Re: **5 Dartmouth Square, Dublin 6.**  
Your Ref: **ABP-305895-19**  
Plan Ref: **0354/19**

### APPEAL COMMENTS

**EXPP:** 0354/19 (Section 5 Declaration Application)

**EXPP:** 0354/19 – Additional Information

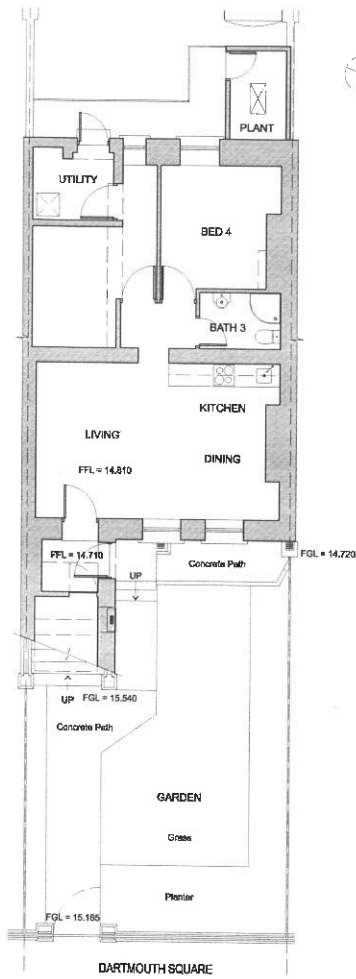
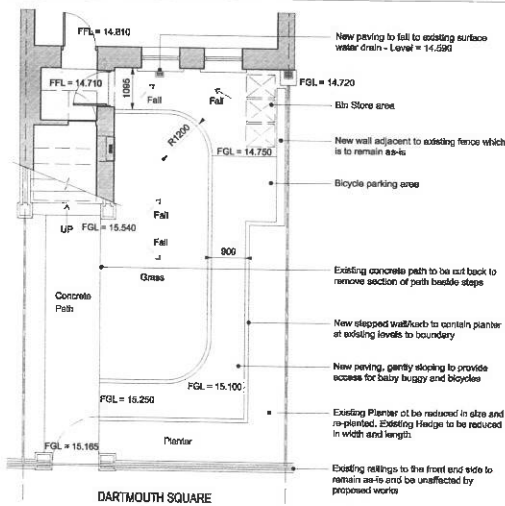
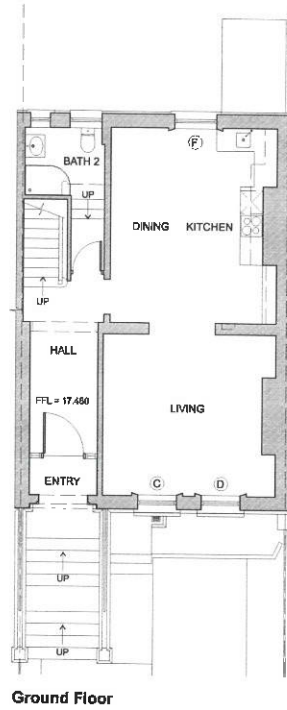
The application does not fully detail the proposed work to the front garden to allow full assessment of the impact on the protected structure. A plan of the proposal notes changes in level indicating a drop of c.500mm. A section showing the impact of the sloping path and grass in relation to the protected structure should be provided. The house sits within a terrace of similar houses, all with the same layout of front façade and garden. The introduction of significantly different level to one garden within the terrace will make the garden inconsistent with the surrounding properties. A drawing showing the impact is therefore required to fully assess the proposed work.

The drawing of the proposed front garden notes a wall to be constructed against the boundary with the house to the north. However no further details on this wall are provided including height and materials. The front gardens of the houses along the terrace are divided by metal railings with hedges grown around the railings in some instances, including the boundary in question. Therefore the introduction of a wall abutting the historic railing will not only impact on No.5 Dartmouth Square but also on No.6 Dartmouth Square, which is a protected structure. The construction of the wall will result in the removal of a section of the existing hedge. Details on the height/depth/length of the wall, an elevation drawing showing its height in relation to the front façade of the house and the material to be used in its construction. This information is to include any proposal for a perpendicular wall at its eastern end.

The proposal does not include any details on the material to be used for the new path other than to note that it will be paving. A *'...stepped wall/kerb to contain planter at existing levels...'* is also noted but the material to be used for this is not provided. The applicant is to submit full details on the colour texture and nature of the material to be used for the path in order to assess the impact of this on the protected structure.

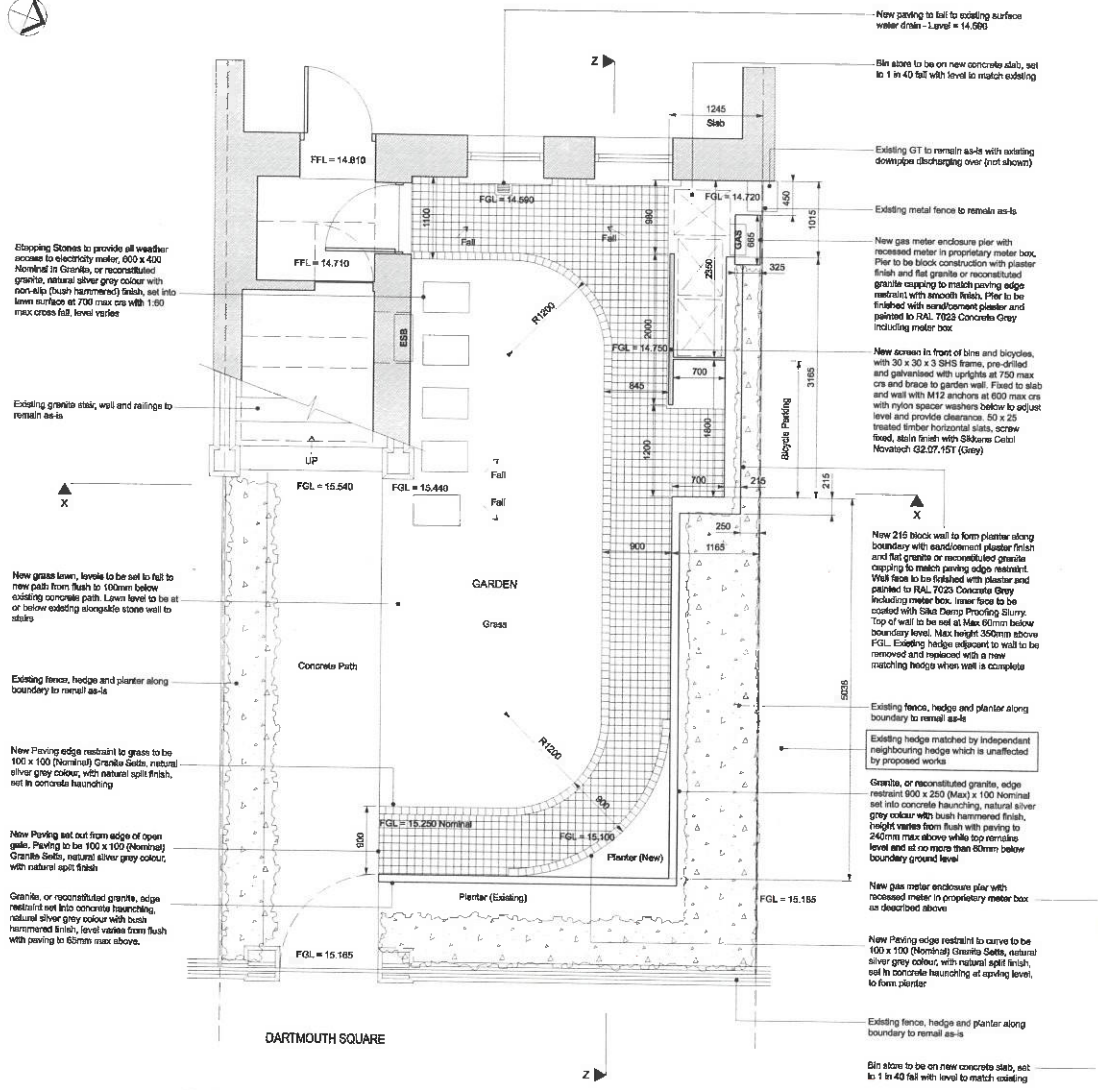
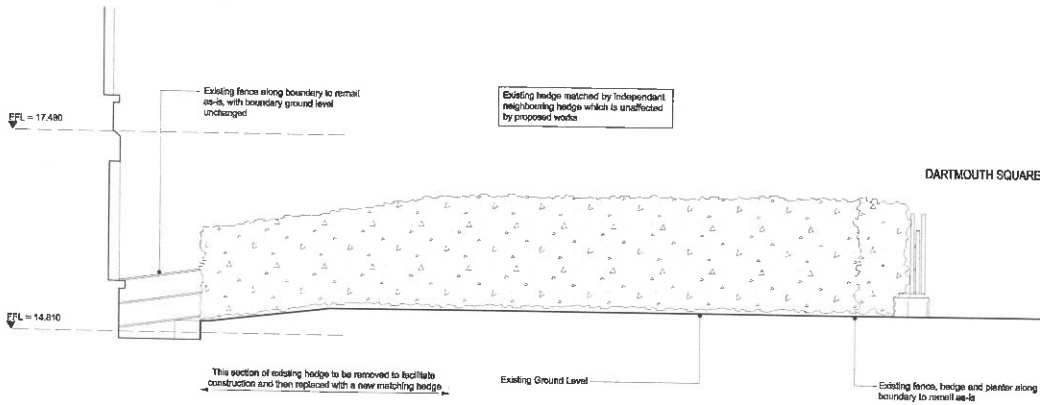
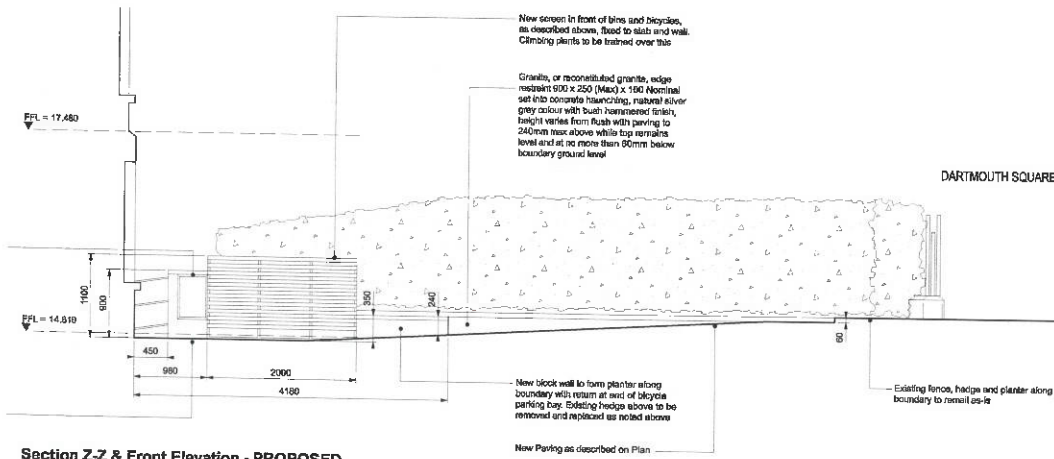
- The Additional Information submitted on behalf of the applicant provides details on the wall to be constructed. The plans/sections/elevations presented indicate that the applicants propose to provide a timber screen 1100mm in height and 700mm in front of the proposed concrete wall along the boundary with No.6. In addition, a gas meter enclosure is proposed directly in front of the boundary railing to the garden of No.6. This was not apparent on the original submission and clearly demonstrates that it is effectively proposed to construct a structure within the front garden. Under Schedule 2, Part 1 of the Planning and Development Regulations, a Class 3 structure cannot be considered exempted development if *'...erected or placed forward of the front wall of the house...'*. A Class 3 structure is considered to be a *'...tent, awning, shade or other object, greenhouse, garage, store, shed or other similar structure'*. The proposed walls and screen to the front of this structure will form a bin store (it is named a *'Bin store'* on the Proposed Section Z-Z & Front Elevation drawing) and, together with the bicycle area to the immediate east, are deemed to be a structure under Class 3 Schedule 2 Part 1 of the Planning and Development Regulations. Its location forward of the front wall of the house implies infers this proposed work is development and therefore requires planning permission.

The proposed landscaping works to the front of No.5 Dartmouth Square will materially affect the character of the protected structure and are therefore considered development. The Department of Culture, Heritage and the Gaeltacht's *Architectural Heritage Protection Guidelines for Planning Authorities* states that *'Proposals for new development within the curtilage of a protected structure should be carefully scrutinised by the planning authority, as inappropriate development will be detrimental to the character of the structure.'* (2011, 199) The proposed walls and screen will be adjacent to the front elevation of the house and clearly visible from within the garden. These form part of substantial landscaping works that will significantly alter the front garden. The Additional Information submitted notes the provision of a new gas meter enclosure adjacent to the bin store and *'stepping stones'* set within the lawn along the route of the concrete path to be removed; these had not previously been indicated. The new paved area will be of granite setts and together with the stepping-stones (also granite) and the raised height of planters along the boundary to accommodate the sloped pathway, the collective effect of the proposed works will see a significant loss of soft landscaping within the front garden. The Guidelines note that *'...regardless of its size, a garden can make an important contribution to the character and setting of a protected structure...'* (2011, 197). The introduction of the sloped paved area, which will introduce a different level within this garden to that of its

surrounding neighbours, will make the garden inconsistent with the surrounding properties and be a significant departure from its own historic design.

The cumulative effect of the proposed interventions to the front garden of the protected structure would materially affect its character and cannot be considered exempted development.

Note: The landscaping works proposed include the provision of a bin store/bicycle storage area, gas meter enclosure, sloping pathway and increased hard landscaping as shown on Drawings 1808-S5-2.1.0 and 1808-S5-2.1.1. The cumulative effect of the proposed interventions to the front garden of the protected structure would materially affect its character and cannot be considered exempted development.

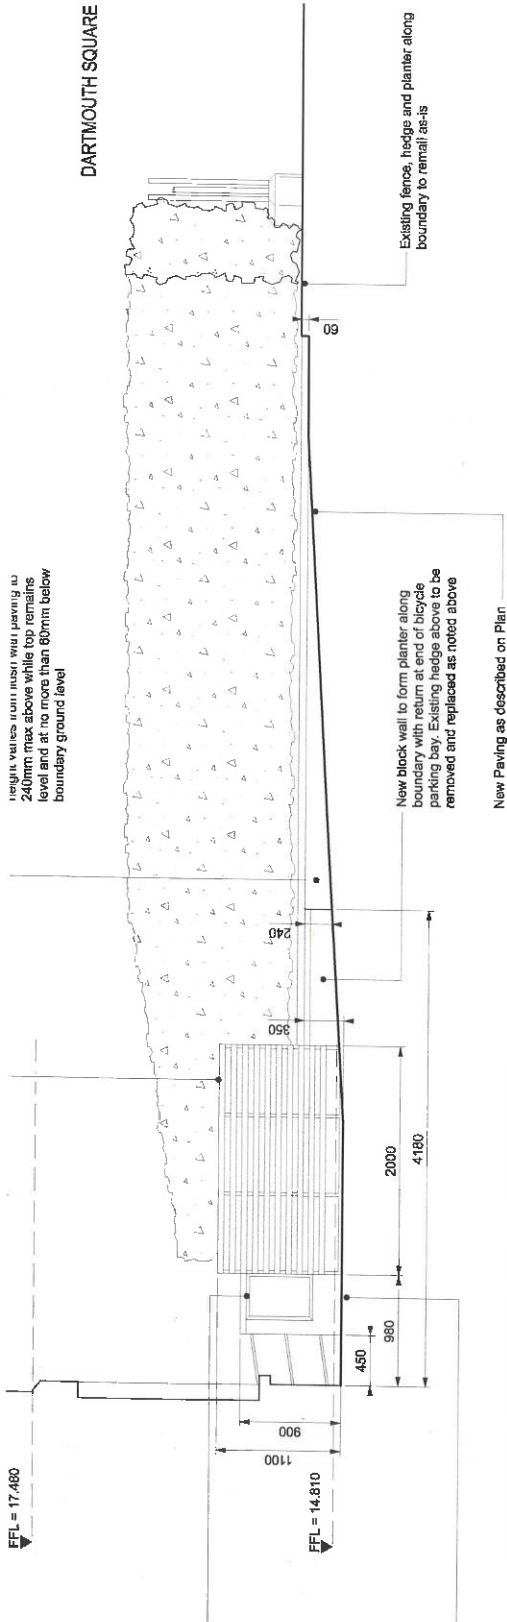
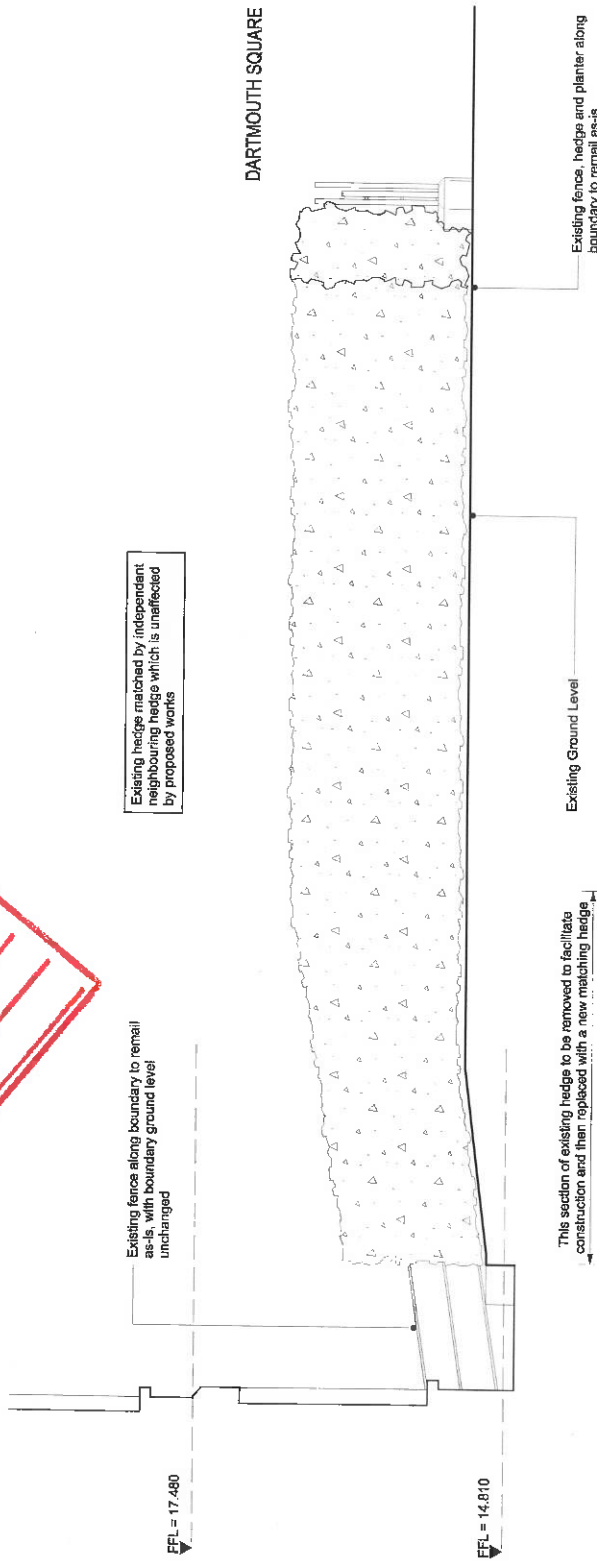
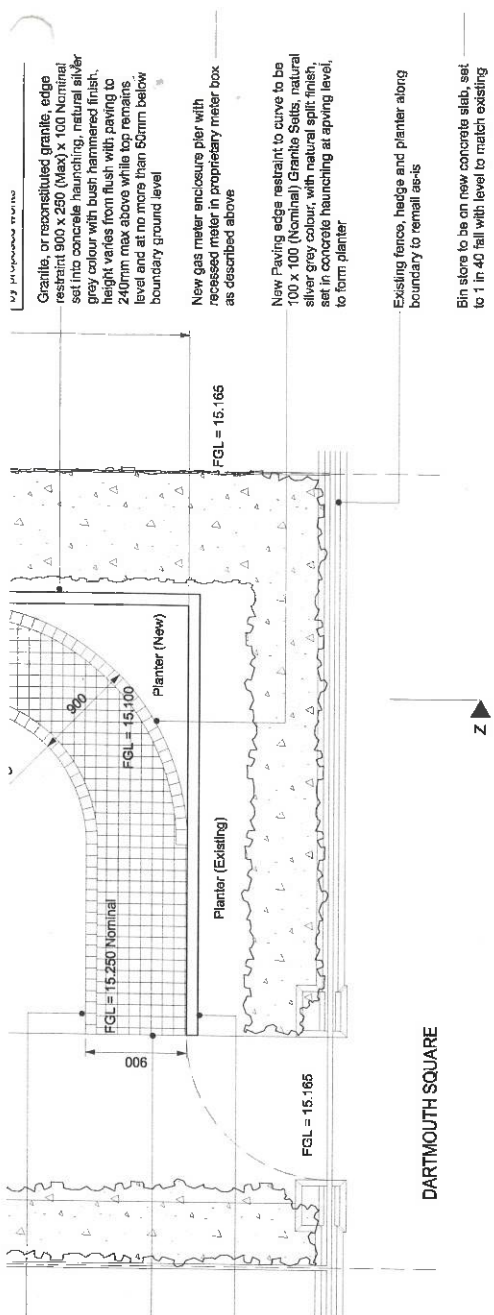
The Additional Information, submitted on the 8<sup>th</sup> October 2019, contained more detailed drawings on the proposals for the front garden which demonstrated that the works would comprise more than originally indicated in the application. The drawings showed the construction of a timber screen 1100mm in height to form a bin store with a screened area for bicycles alongside this. Notwithstanding the impact of this structure within the curtilage of the protected structure and on its boundary with No.6 Dartmouth Square, under Schedule 2, Part 1 of the Planning and Development Regulations, a Class 3 structure cannot be considered exempted development if *'...erected or placed forward of the front wall of the house...'*. A Class 3 structure is considered to be a *'...tent, awning, shade or other object, greenhouse, garage, store, shed or other similar structure'*. The proposed walls and screen to the front of this structure will form a bin store (it is named a *'Bin store'* on the Proposed Section Z-Z & Front Elevation drawing) and, together with the bicycle area to the immediate east, are deemed to be a structure under Class 3 Schedule 2 Part 1 of the Planning and Development Regulations. Its location forward of the front wall of the house infers this proposed work is development and therefore requires planning permission.

Under Section 2(1): Interpretation of Part 1 of the Planning and Development Act 2000 (as amended), the garden of No.5 Dartmouth Square is considered part of the protected structure. The Department of Culture, Heritage and the Gaeltacht's *Architectural Heritage Protection Guidelines for Planning Authorities* states that *'Proposals for new development within the curtilage of a protected structure should be carefully scrutinised by the planning authority, as inappropriate development will be detrimental to the character of the structure.'* (2011, 199) The drawings submitted as Additional Information show the proposed landscaping works to the front garden as being substantial and will result in a significant alteration of the front garden. The amount of hard landscaping to the front garden would be significantly increased and the introduction of the sloped pathway, which would reduce the garden level in part by up to 0.5m. This would introduce a different level within the garden to that of its surrounding neighbours, would make the garden inconsistent with the surrounding properties and be a significant departure from its own historic design.

The in-combination or cumulative effects of the alterations to the front garden, including the provision of the bin store and bicycle area, would materially affect the character of elements of the protected structure that contribute to its special character. Therefore, due to the nature
